DEVELOPMENT REVIEW BOARD
SUPPLEMENTAL SUBMITTAL

PROJECT NO. PR-2019-002651
Application No. SD-2019-00133

SUBMITTAL DESCRIPTION: Revised page 2 of plat, Response to comments (Hydrology & transportation), additional surveys & exhibits

DRB Project Number: 2019-002651
Sunport Park (Plat of Parcel 2-A)

Plat of
Parcel 2-A-1
Sunport Park

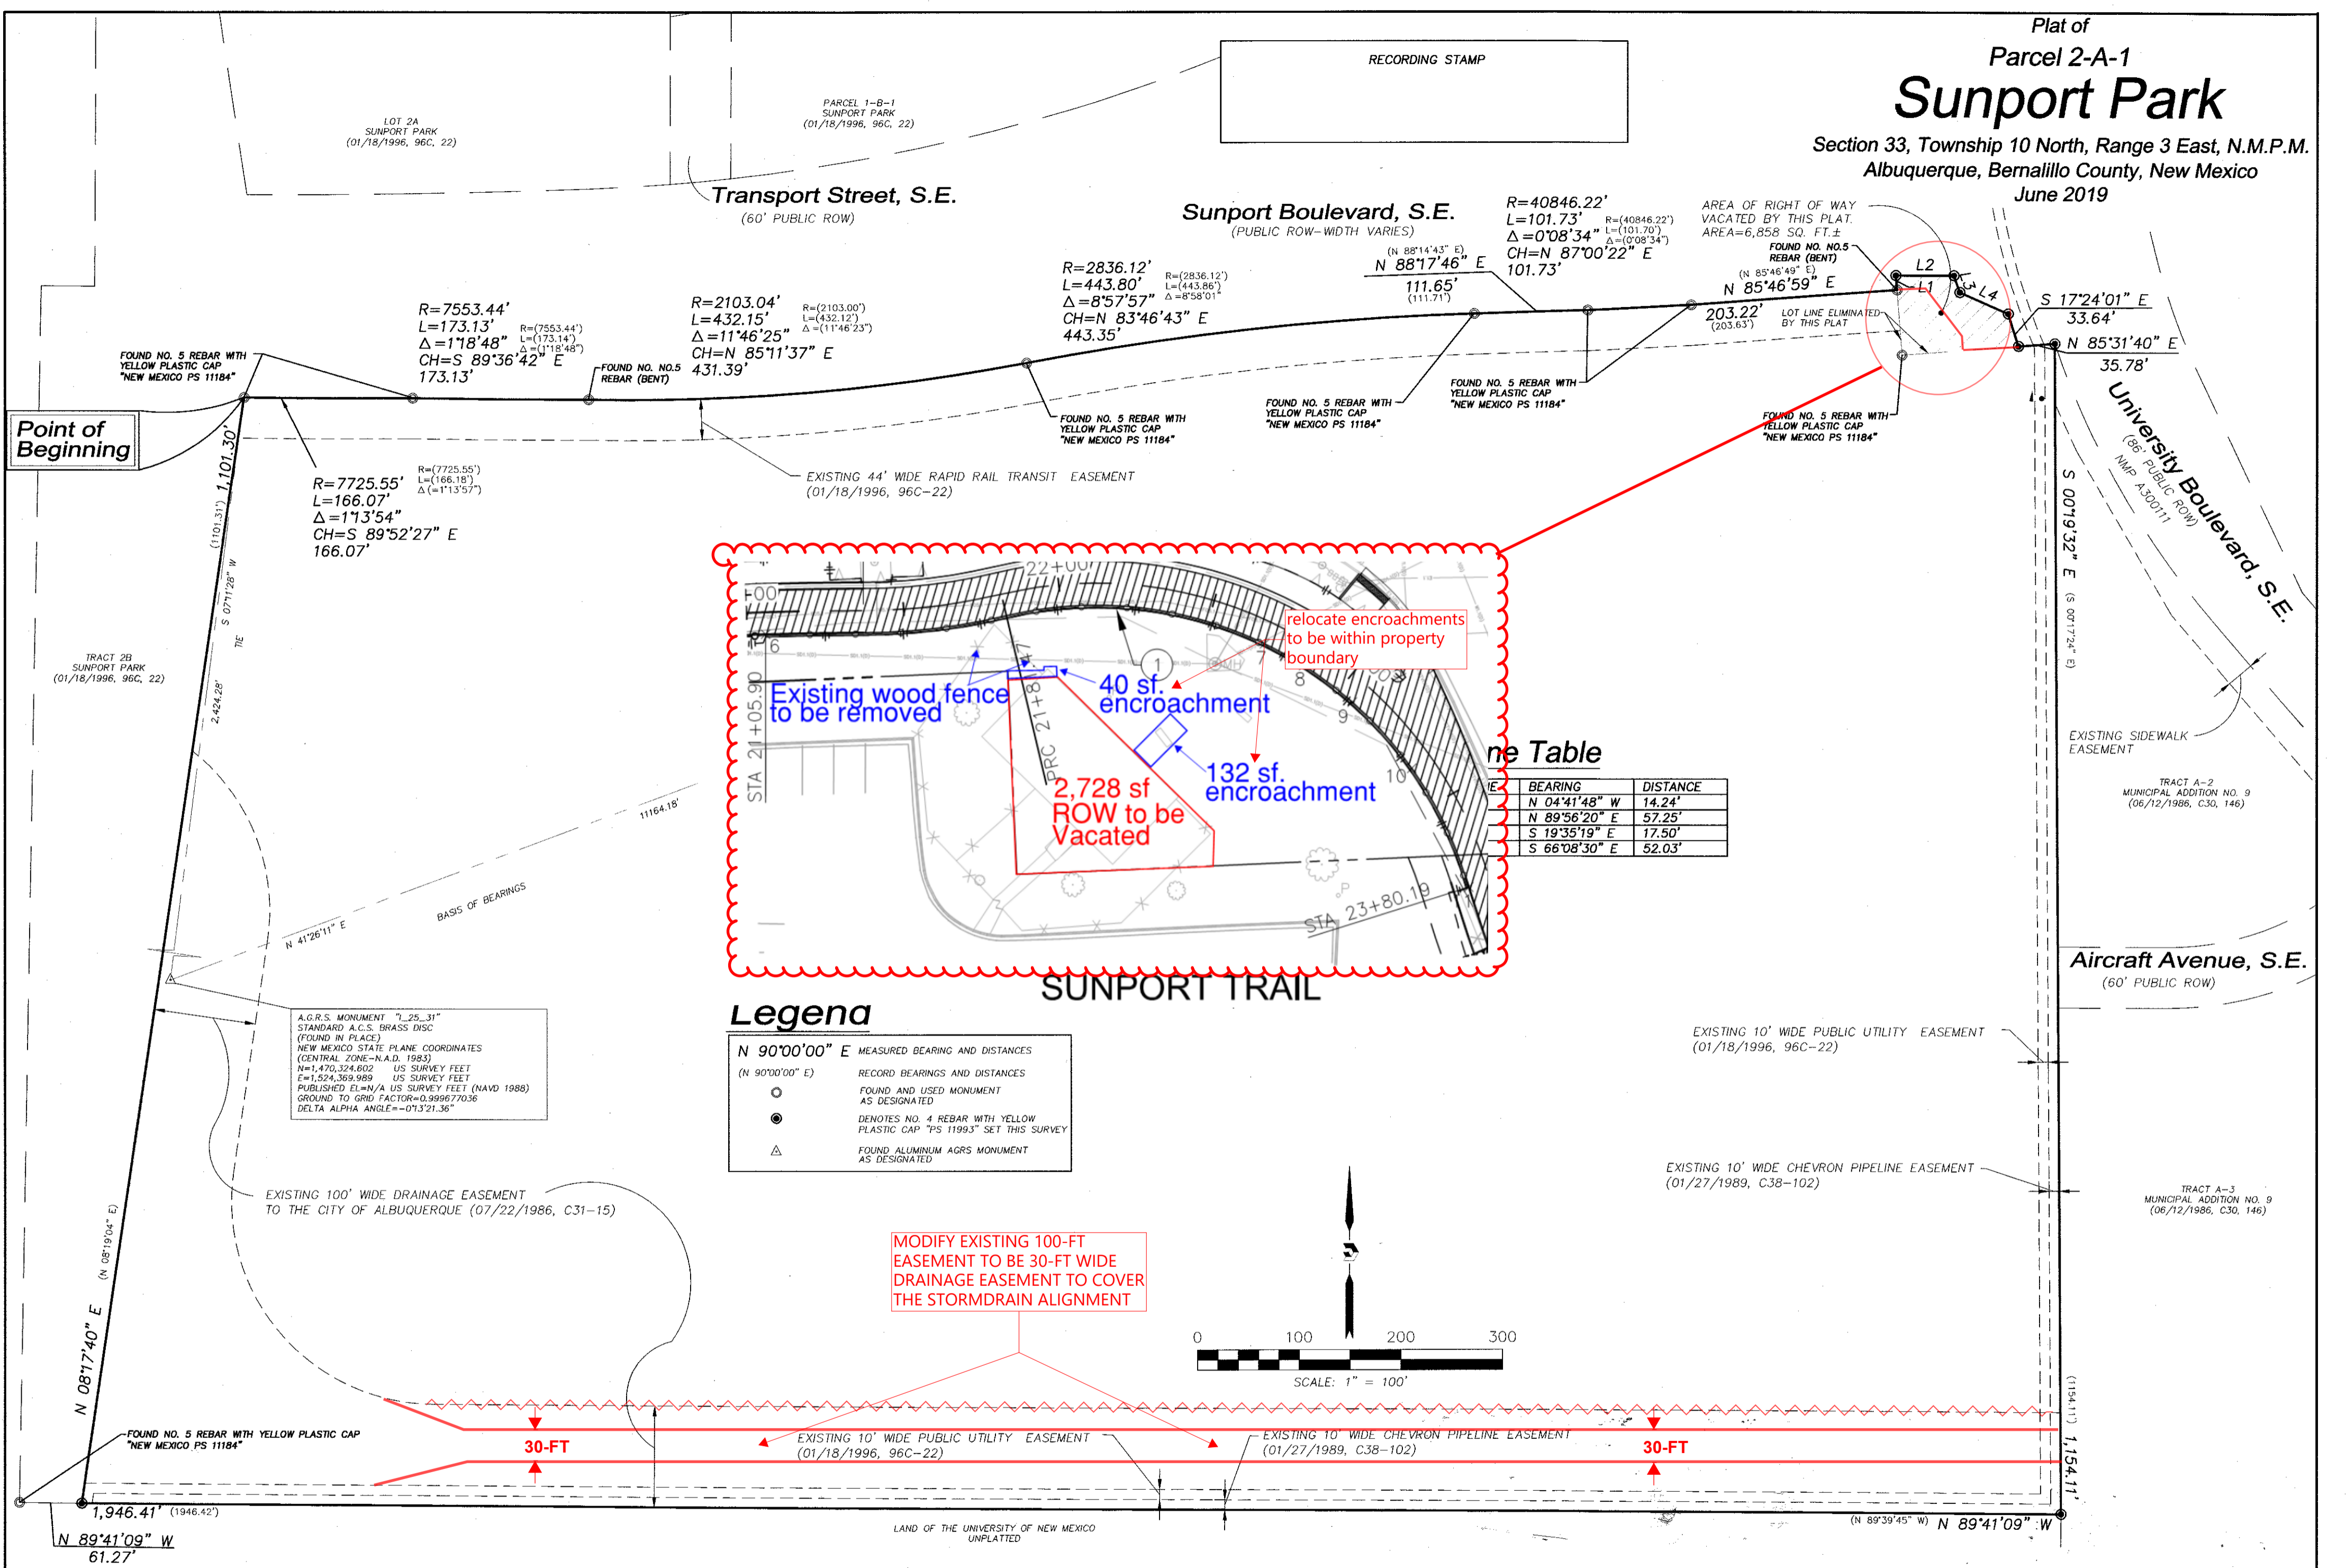
1. Exhibits have been provided to show that the vacation does not impact the "University Bikeways Phase 2 Project". Based on current submittal, it is not clear what the proposed right-of-way vacation is.

- Provide a topographic and features survey showing the exact locations (**vertical** and horizontal) of the existing public storm drain and the existing buildings/carports **in both the NE corner and south side** of the property.

- Provide an exhibit, per the DPM Ch.22.6.C.2., showing the required drainage easement (or ROW width) in the NE corner, include the building location.
Exhibit included with the resubmittal details the proposed ROW width.

- Provide an exhibit, per the DPM Ch.22.6.C.2., showing that the requested 30' drainage easement on the south side is sufficient; include the carport locations.
Exhibit attached.

- The easement on the south side will need to be vacated and the replacement easement granted as two simultaneous actions. It cannot be "reduced" in one action.
Request with this submittal is the vacation and replat of the easement along the carport section.

We have coordinated with DMD on the bikeway project and the vacation does not impact the project. As requested by DMD, the plat shows the City's Right of Way Taking Parcel 2-1 for the University Blvd. Bikeways-Phase II Project No. 795692 currently in condemnation (D-202-CV-201802511) which will resolve this matter.

See attached the DMD bikeway plans which details the public storm drain through the right-of-way. In addition, attached is the survey with the storm drain through the property on the south side in reference to the carport that was surveyed to confirm the aligned and the vacation and replat of the stormdrain easement.

- If the building encroaches on the required drainage easement (or ROW width), it will need to be removed prior to vacating the ROW (NE Corner).
There are no encroachments.

- If the carports encroach on the City existing drainage easement along the south side of the property, they may need to be removed prior to Plat.
There are no encroachments.
